Application for a non-material amendment following a grant of planning permission.

Proposed new dwelling and detached garage

H06-1230-18

swapping of door and window in utility room

Drawing No. 18/532/PA/003A

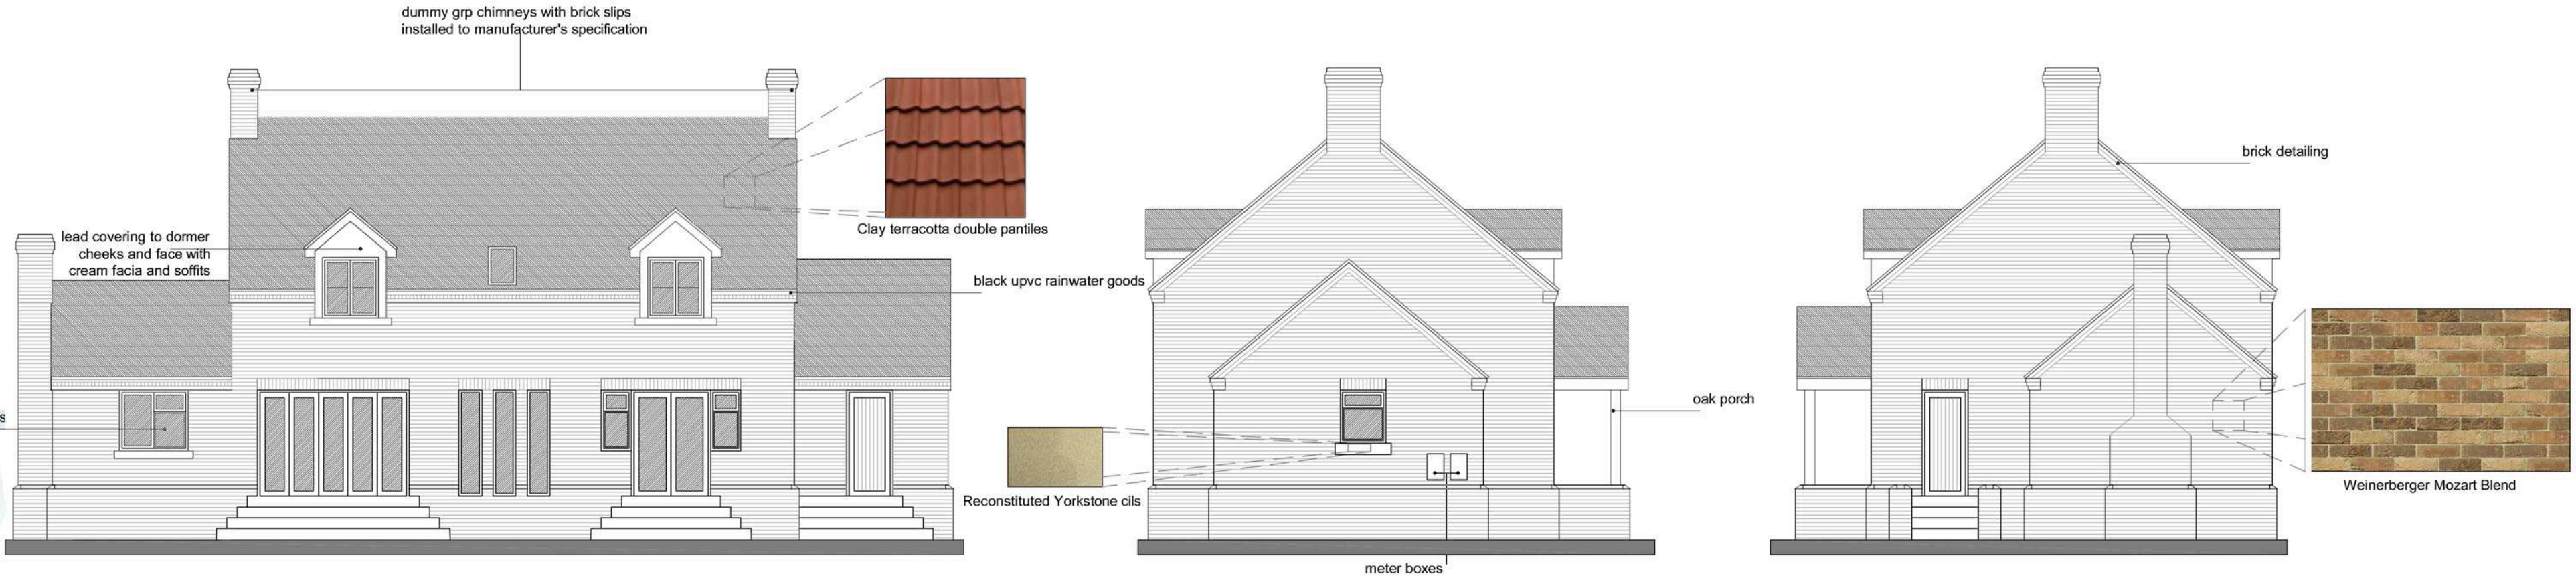
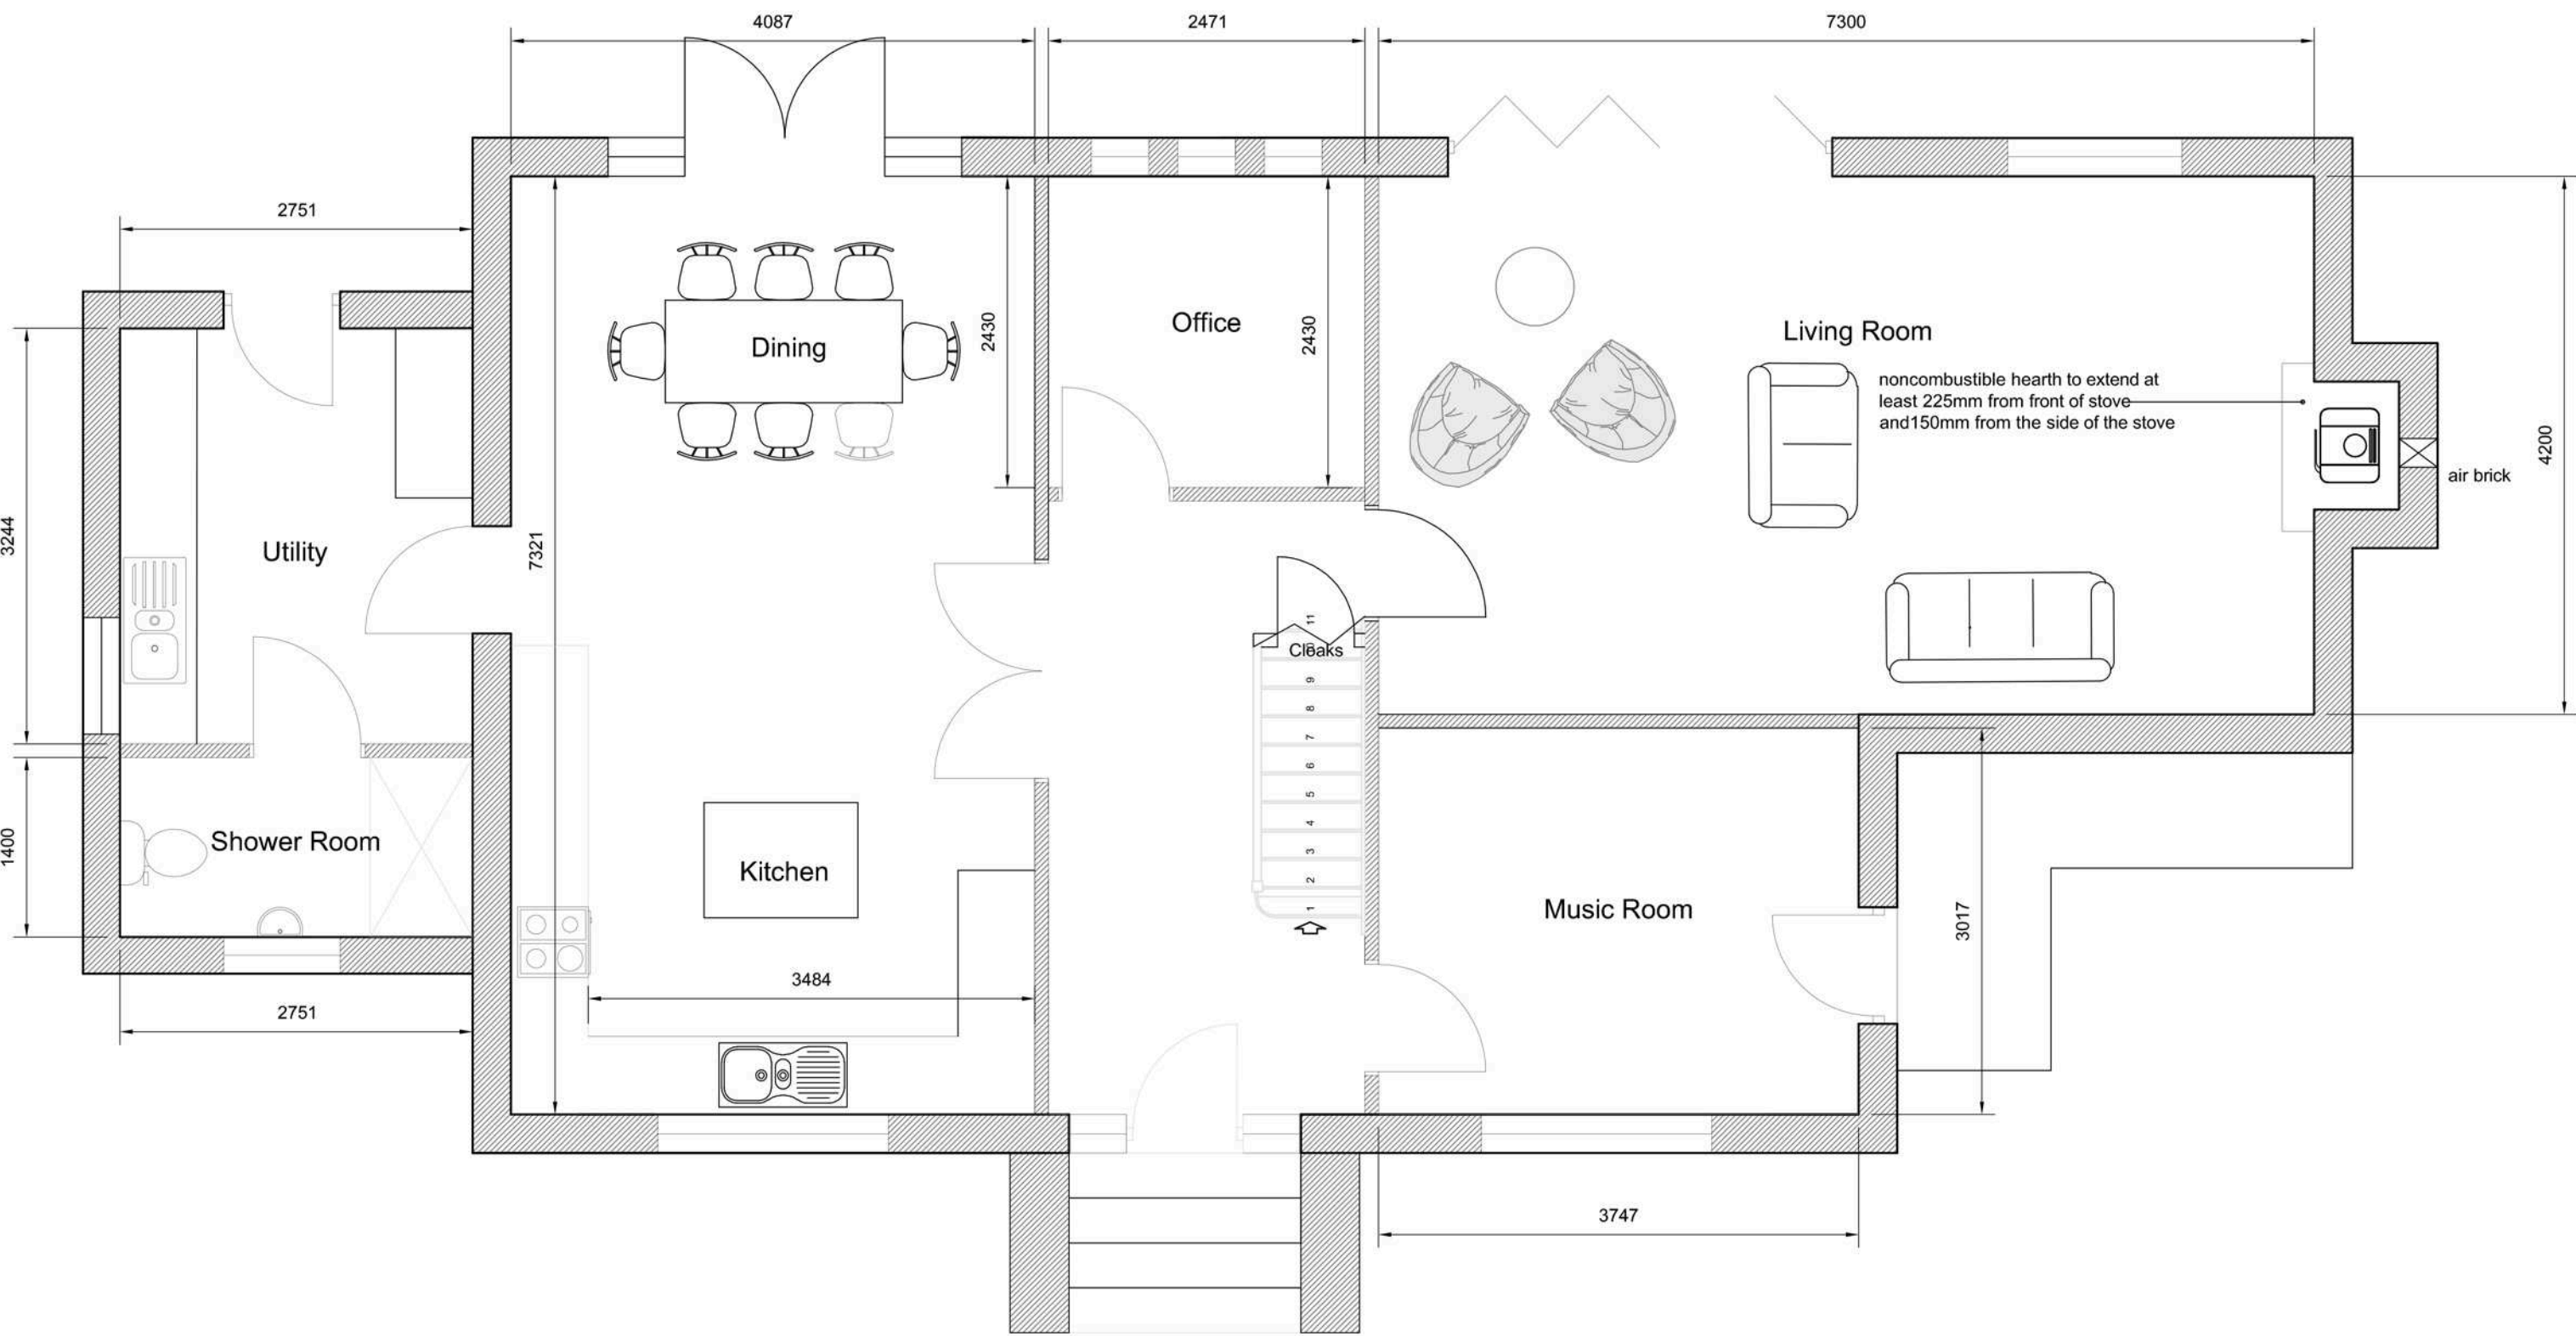
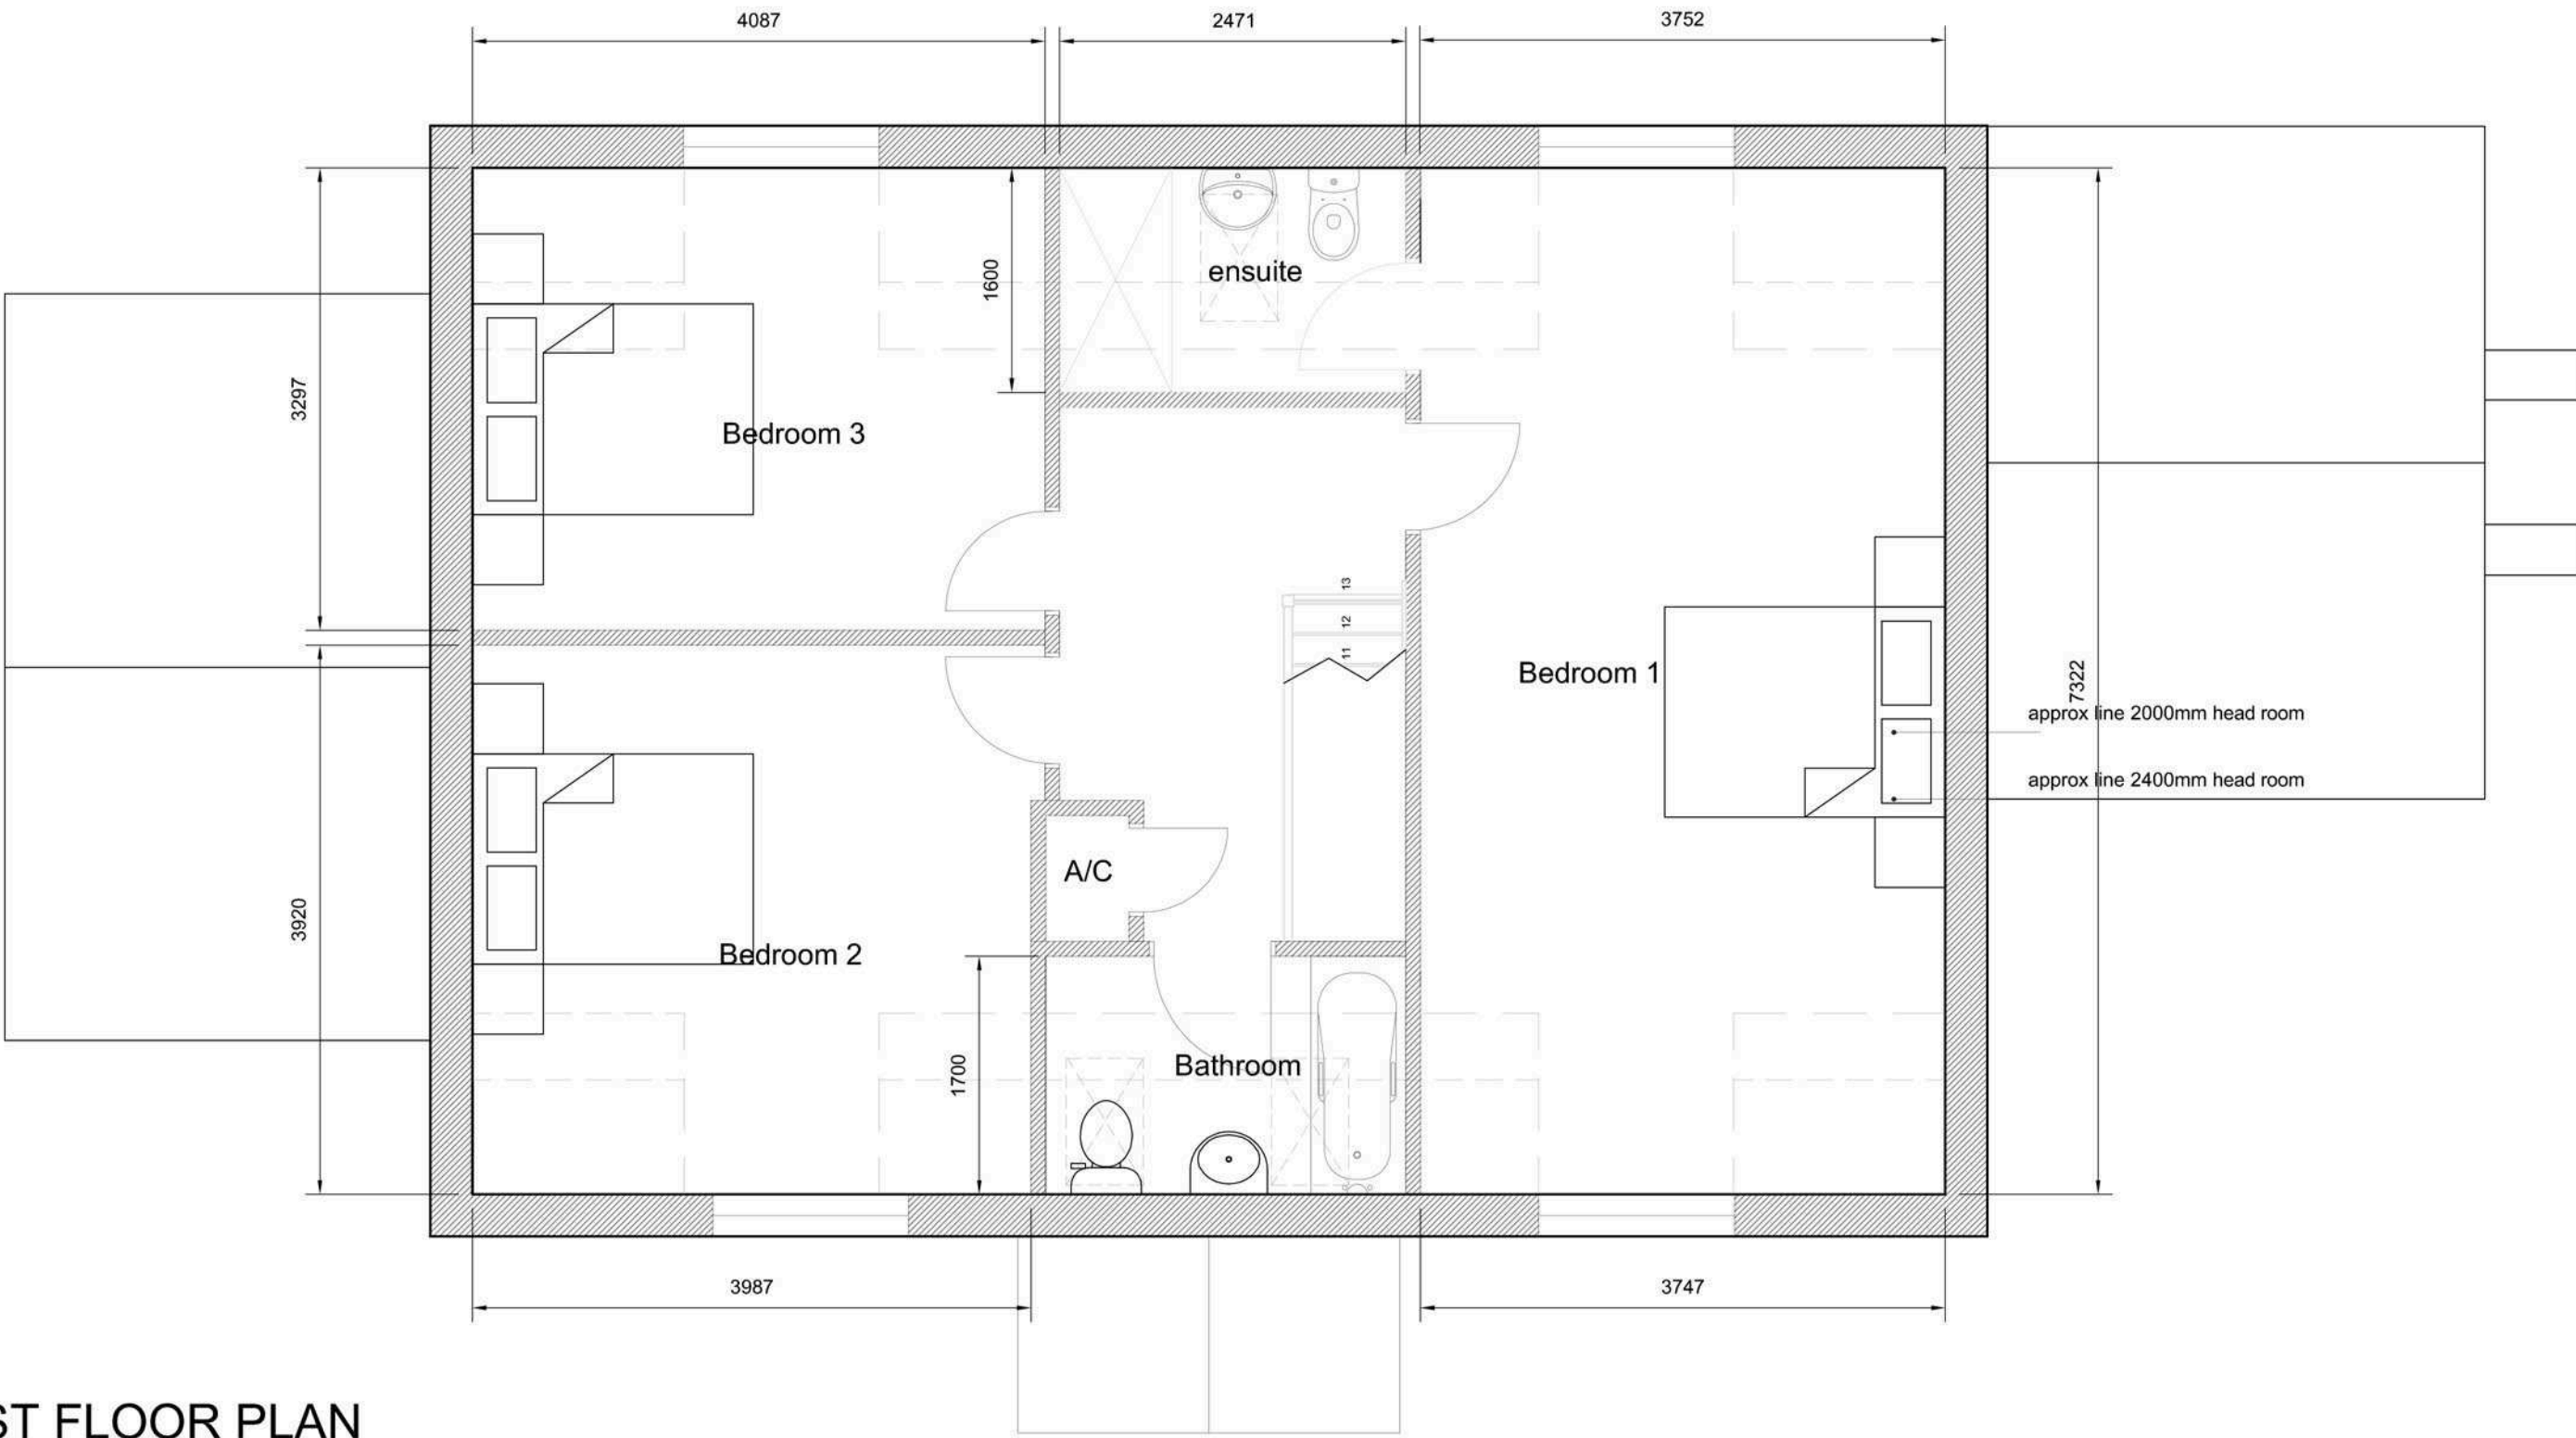
18/532/PA/003

18/532/PA/003A
